**APPLICATION BY SEGRO PROPERTIES LIMITED FOR THE EAST MIDLANDS GATEWAY PHASE  
2 AND HIGHWAY ORDER 202X**

**Deadline 4 Submission**

**EAST MIDLANDS INTERNATIONAL AIRPORT LIMITED**

EMG2 SITE ACCESS CL LONGSECTION
SCALE: H 1:2500, V 1:500. DATUM: 85.000

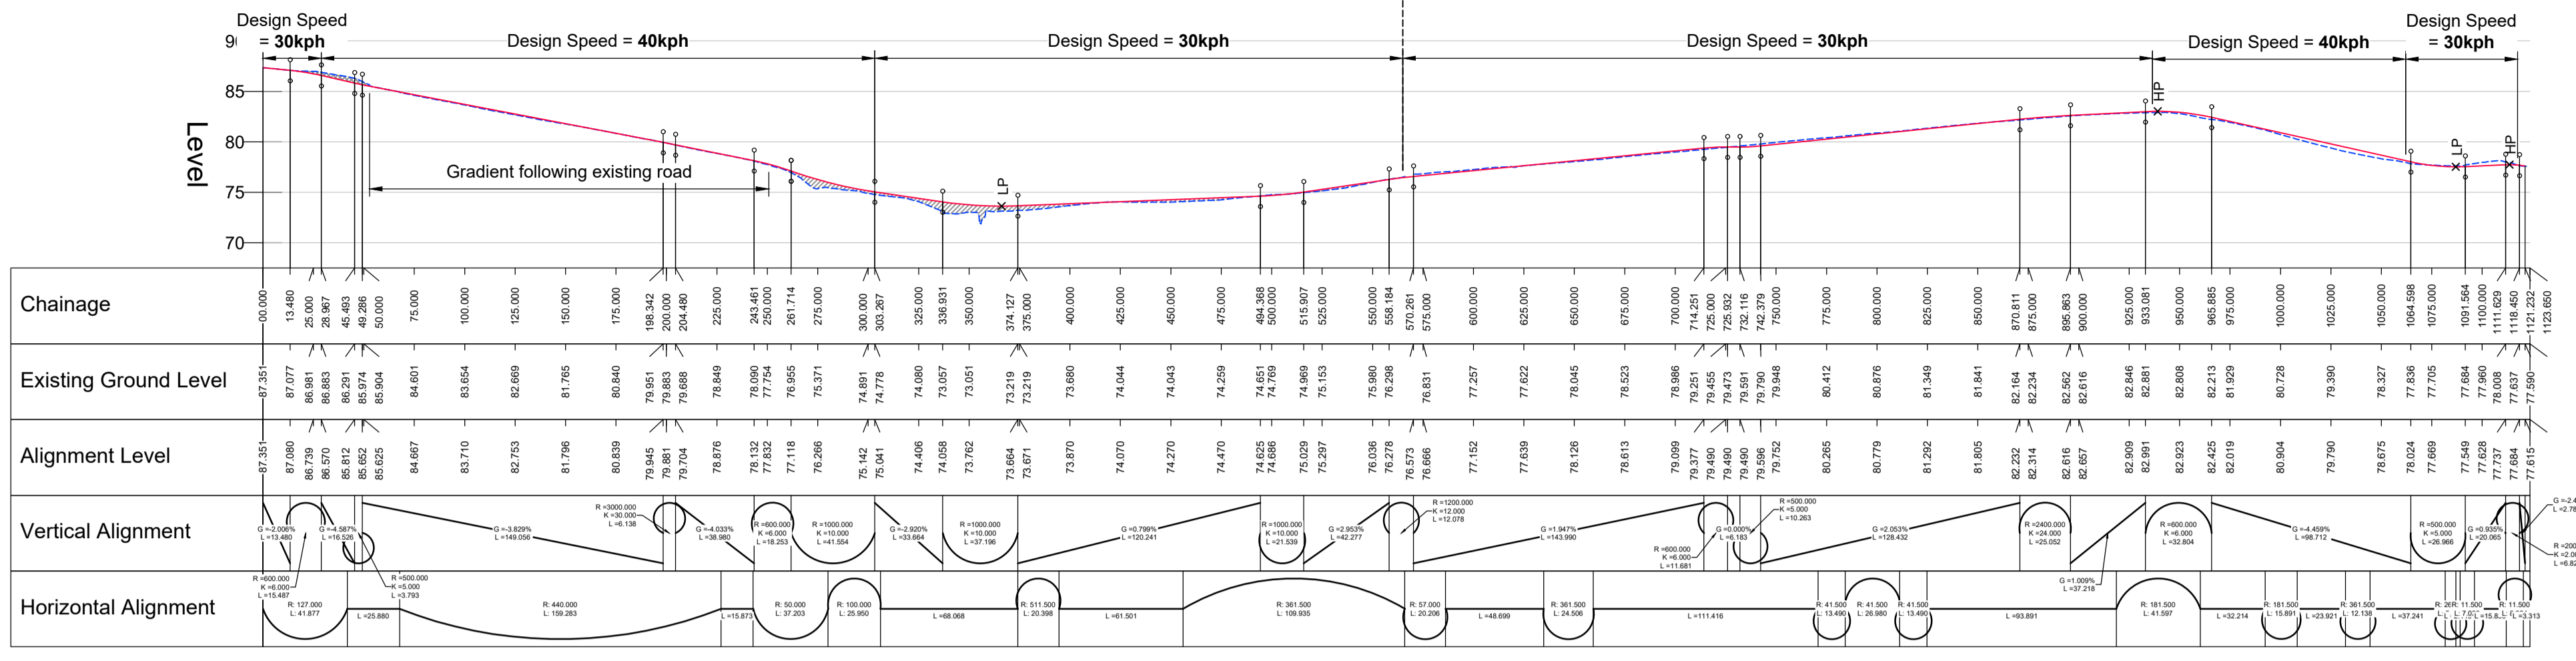
<p>The long section indicates that between Chainages 0m and 700m the proposed link road generally follows the existing ground profile. Between approximately Chainages 700m and 950m, the road rises at the maximum practicable rate within design standards to meet the proposed bridge location and intersection with the A543.</p> <p>As the vertical alignment of Package 4 is unknown, it is not currently possible to determine whether sufficient clearance would exist between the two schemes. Additional clearance may be achievable by lowering the EMG2 link road south of its bridge; however, further investigation would be required. Any reduction in levels would likely need to be accommodated further south, as the alignment appears constrained to the north by the proposed overbridge and to the south by the M1 carriageway.</p> <p>An alternative EMG2 arrangement shown within the Package 4 information replaces the A453 bridge crossing with an underpass beneath the A453. This option could provide greater flexibility to lower the EMG2 alignment and increase separation between the two schemes. However, the impact on surrounding infrastructure and overall feasibility would require further assessment.</p> <p>(iii) For structures located on recognised high-load routes, design standards typically require a minimum headroom of 6.45m plus any allowance for road sag curvature (6.45m + S) (DMRB document CD127 para. 4.1). As the sag curve information has not been provided, this assessment considers only the base requirement.</p> <p>The proposed clearance of 5.84m is therefore below the standard requirement of 6.45m + S. It is understood that a Departure from Standard has been submitted and agreed by the Overseeing Organisation but as we don't have sight of the mitigation measures proposed it is not clear what has been agreed. Such a submission would typically consider the impact on affected vehicles, alternative routing arrangements, and warning signage. No supporting information on these matters has been provided.</p> <p>An alternative route between the M1 and the A453 exists south of East Midlands Airport and may provide a suitable diversion for northbound abnormal loads. For southbound movements from M1 Junction 24, this would potentially require vehicles to continue to M1 Junction 23 before returning northbound. The EMIA team would need to review the departure agreed and the alternative routes before it can confirm the operations of the airport would not be adversely affected.</p>
